Nestle Hayes  
Schedule 2 - Response to Consultation  
17 August 2017

Scale: 1:100 @ A1
 Date: JULY 2017
 Drawing: 642.11.01
 Revision:

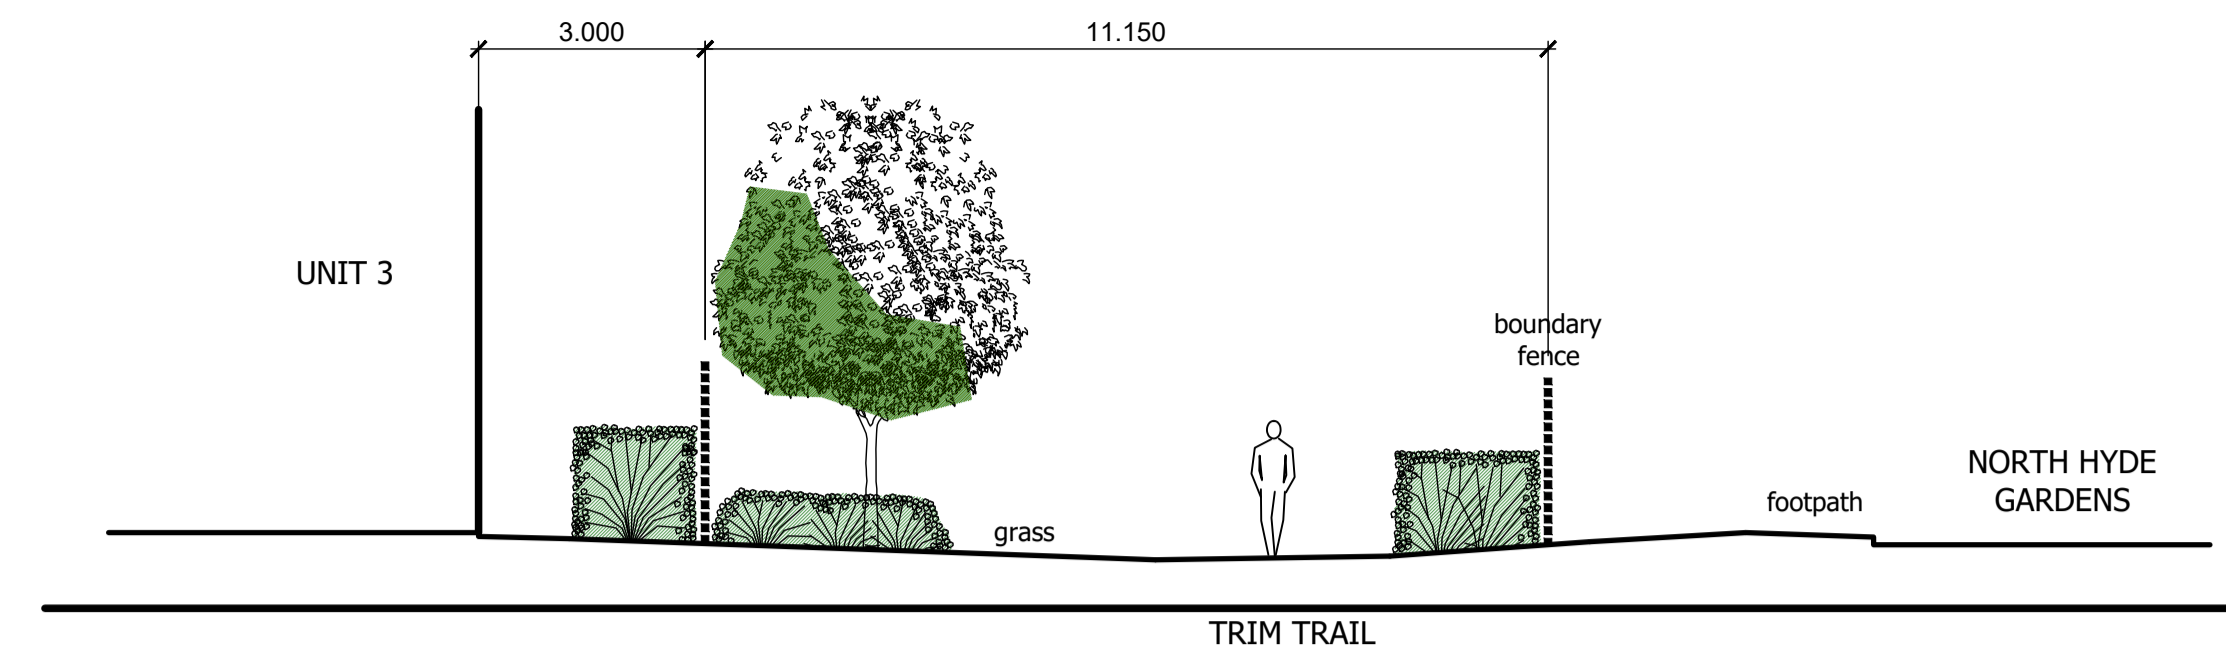
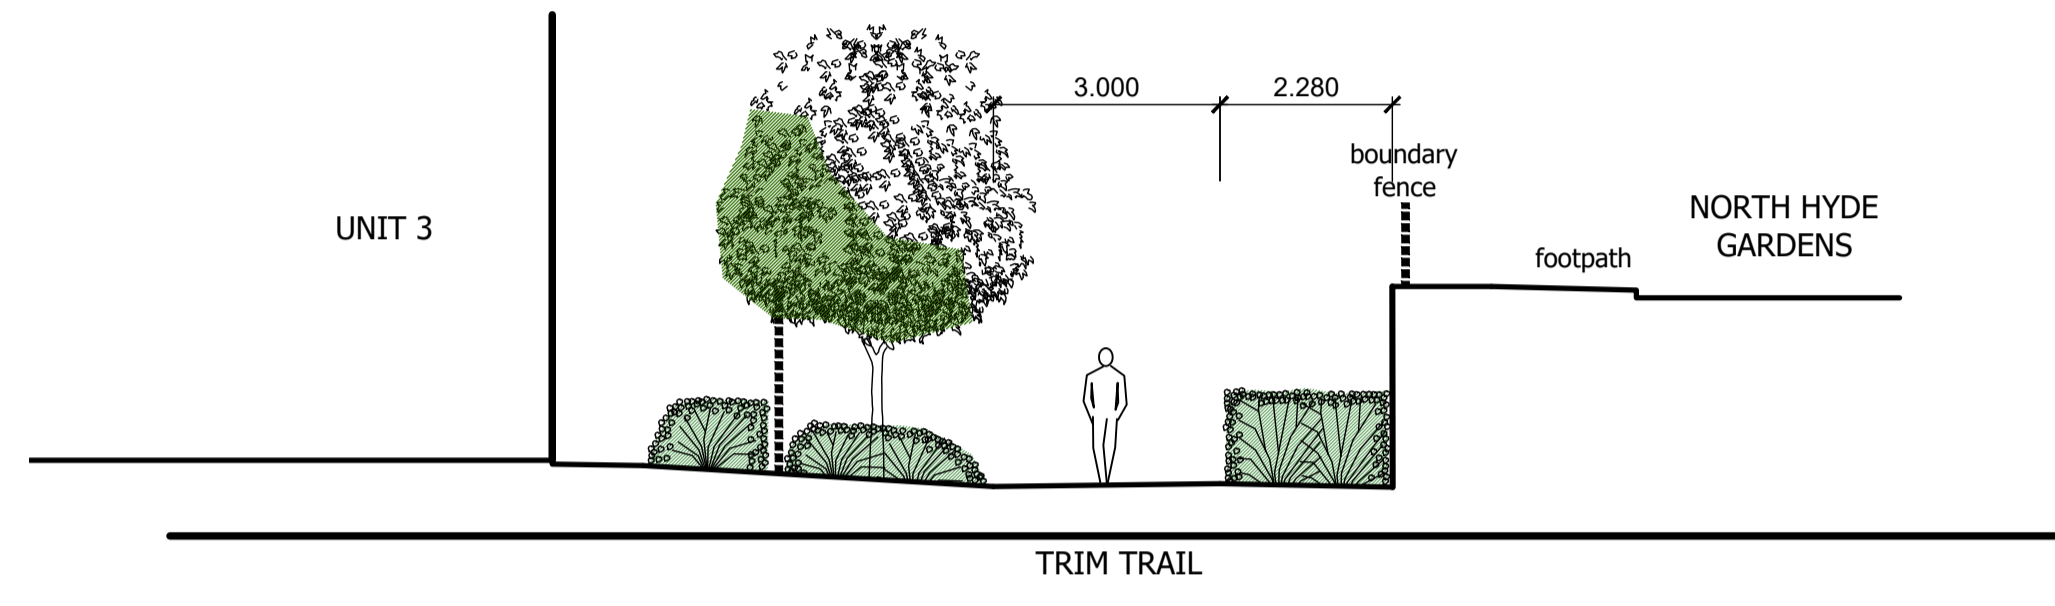
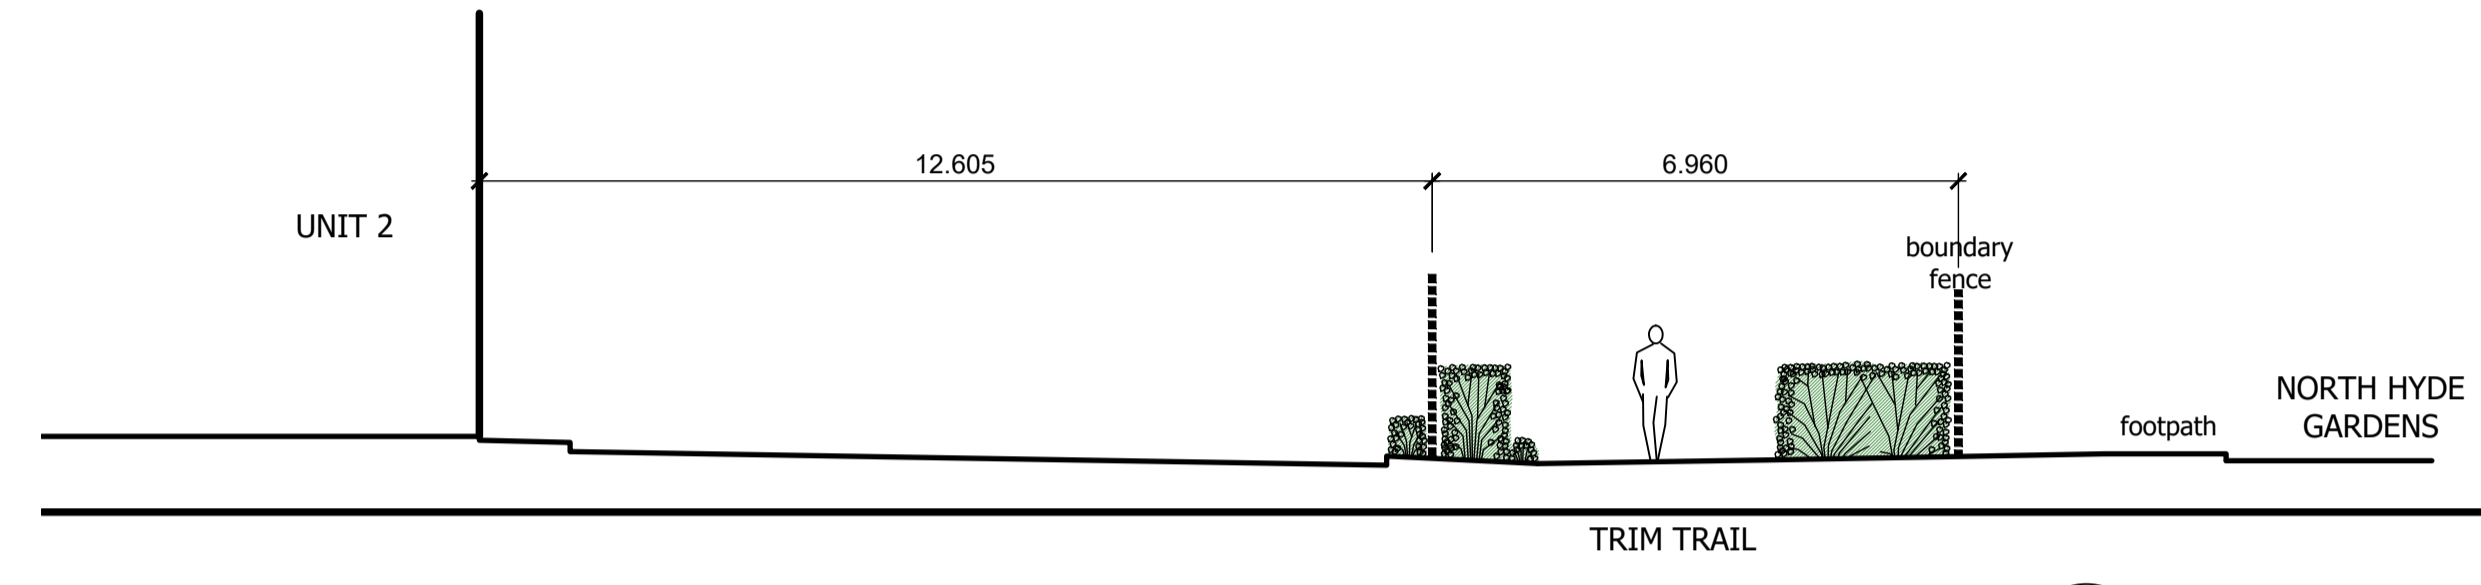
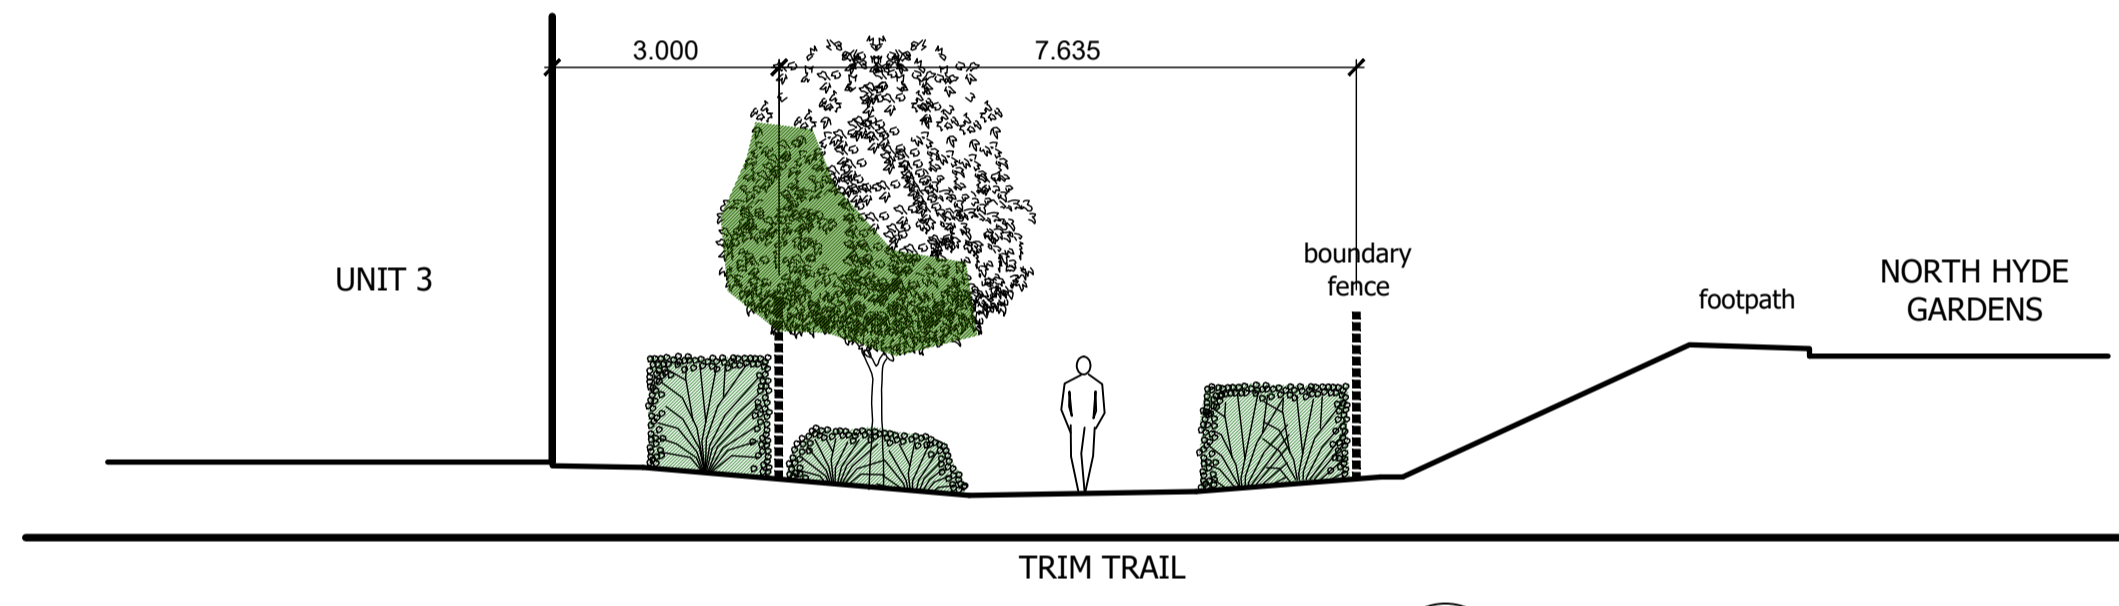
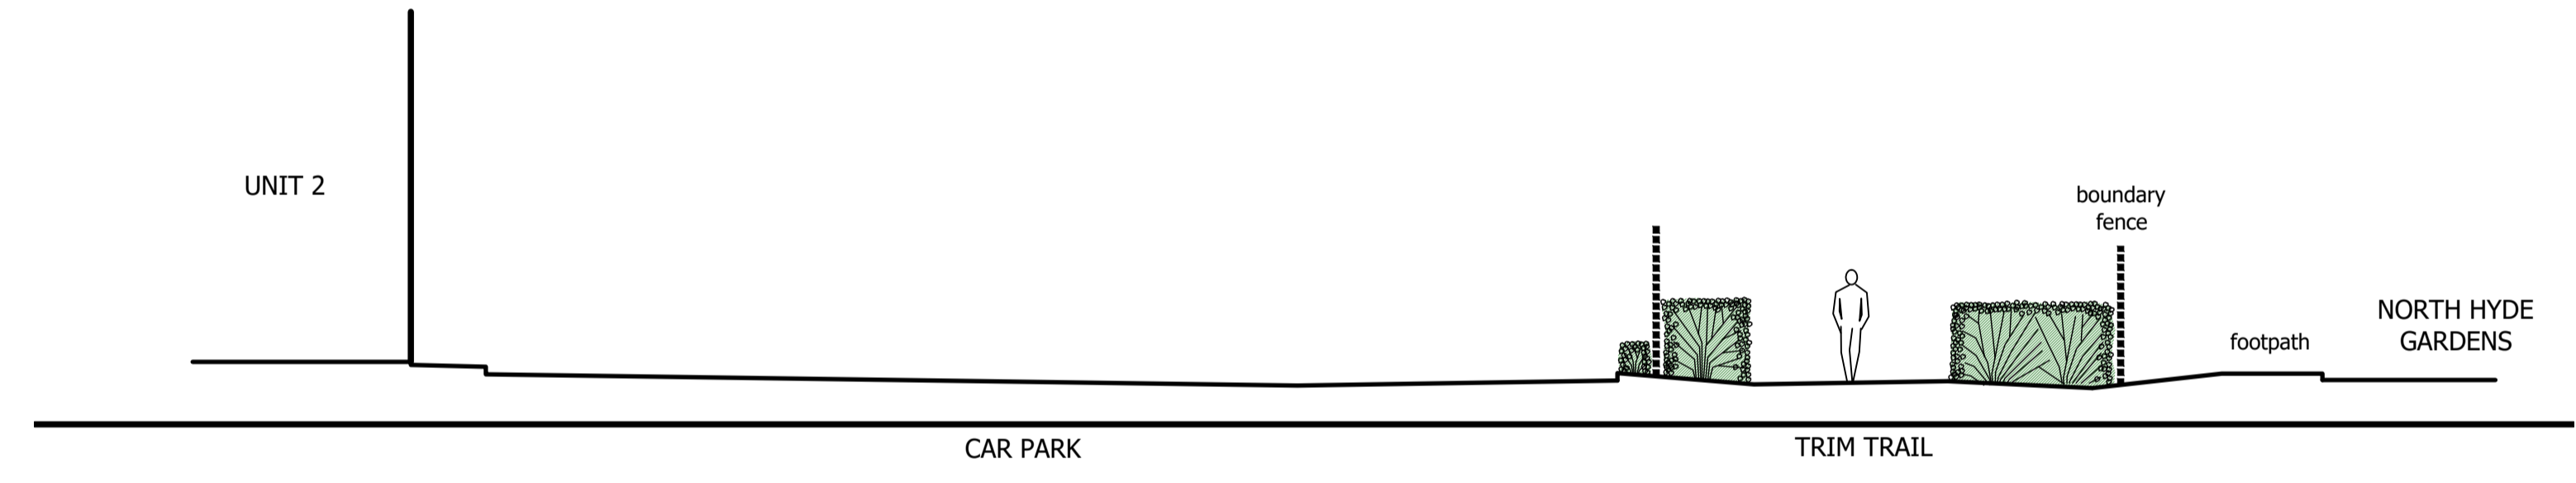
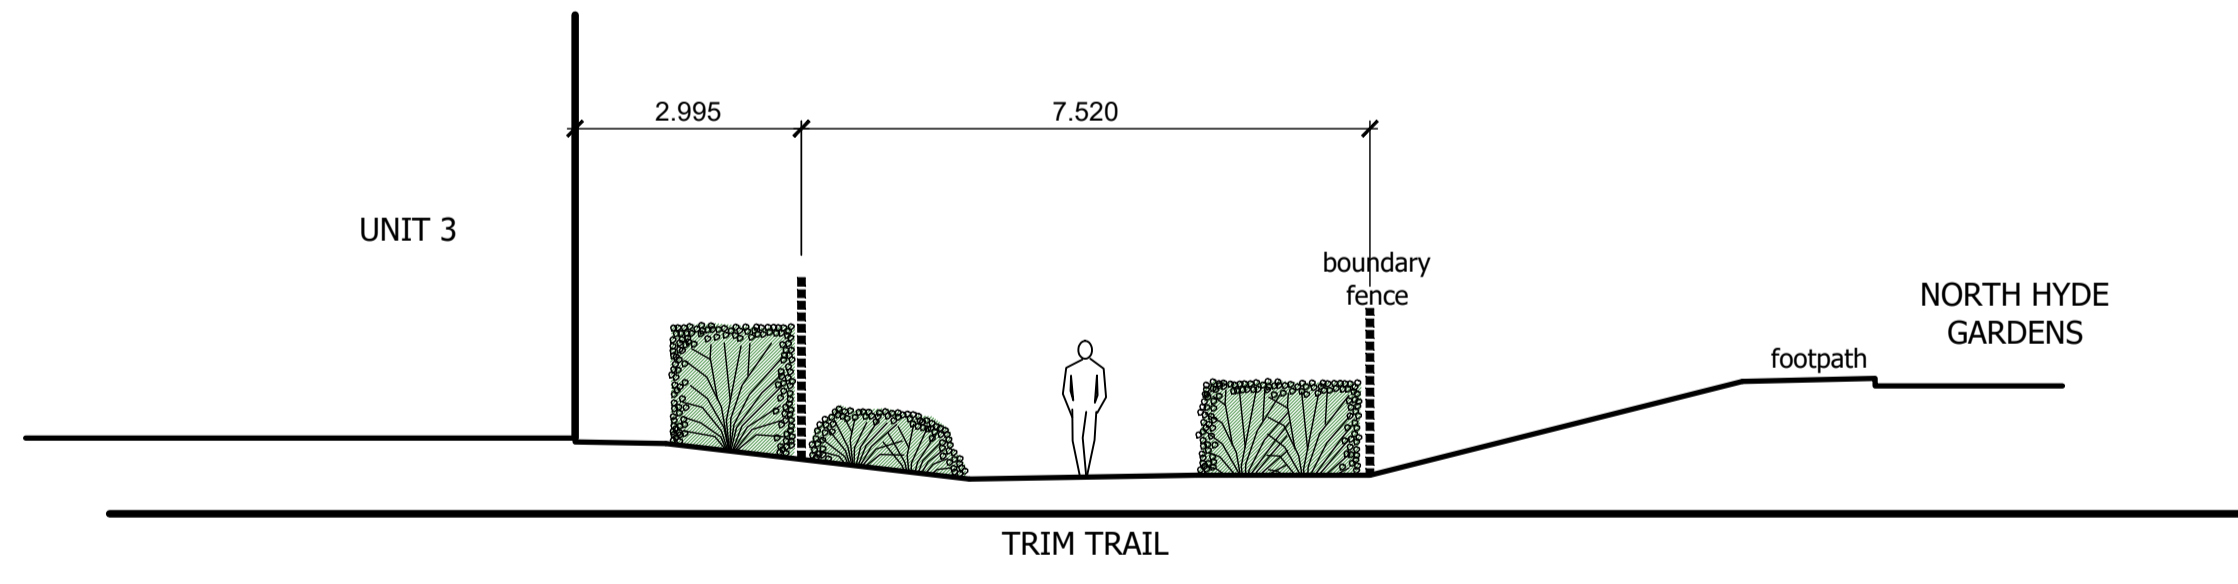
Moorings	Team to explain process that has been engaged to accommodate moorings and justify what is proposed.					Further meeting to be held with Canals and Rivers Trust - response to follow.
<b>Gillespies/TALA</b>						
Canal	Team to provide sections of relationship of landscaped area with canal		YES	YES		See TALA drawing 642.11.02
Trees in Wallis Gardens	Gillespies/Aspect to respond on concern with the retention/impact on trees adjacent to the south west part of Block G.					See Gillespies sketchbook 12 pack
Tree Pits	Gillespies to provide tree pit details					See Gillespies sketchbook 12 pack
Greening of Industrial Scheme	TALA to respond on the concern that the commercial service yards aren't green enough. LBH has also asked for living walls and living roofs. We need a comprehensive response on these matters as it was clear that officers were of the view that more could be done to "green" the commercial proposals. This point was reiterated in the context of the proposed data centre use. LBH members are switched on to the fact that ~10% of the carbon footprint of the Borough is created by datacentres, so in order to ensure the commercial scheme is sustainable, the proposals should "go over and above" to ensure its green credentials					Response to follow

1:2000 scale SITE LAYOUT

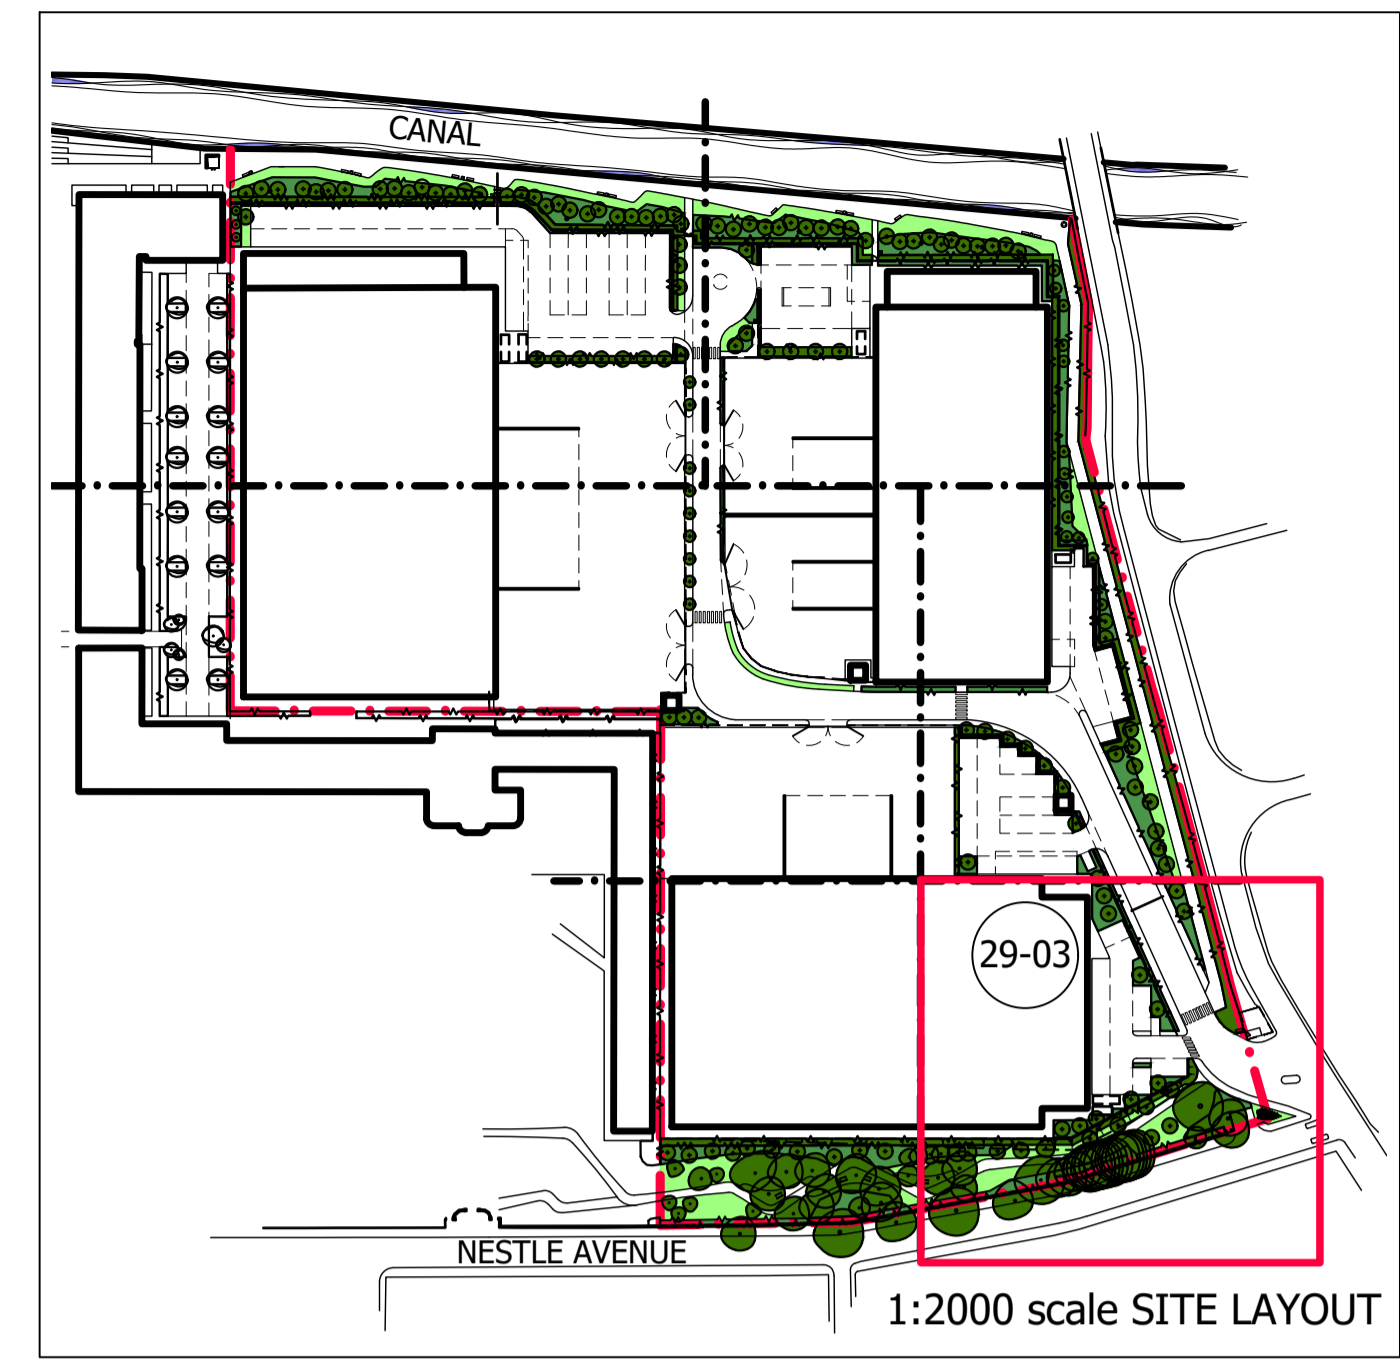
Industrial Entrance	Consideration to be given to layout of entrance to the commercial estate – the pedestrian crossing for the trim trail is convoluted		YES	YES	YES	See TALA planting drawings 642.29.03 and 642.39.03. These have been amended to reflect the boundary modification at the sub-station and additional planting beside the pedestrian crossing to allay concerns of random crossing points by trim trail users.
Trim Trail	Cross sections/views of trim trail at the east of the site to be provided – officers were concerned at the quality of the environment and whether pedestrians would be able to navigate to the canal		YES	YES		See TALA drawing 642.11.01
<b>Markides</b>						
Bus layby	See above in Landscape/Masterplan					Commentary provided in Markides Associates technical note.
Cumulative Assessment	LBH to confirm quantum of development on adjacent sites to verify assumptions made in the cumulative assessment					Commentary provided in Markides Associates technical note.
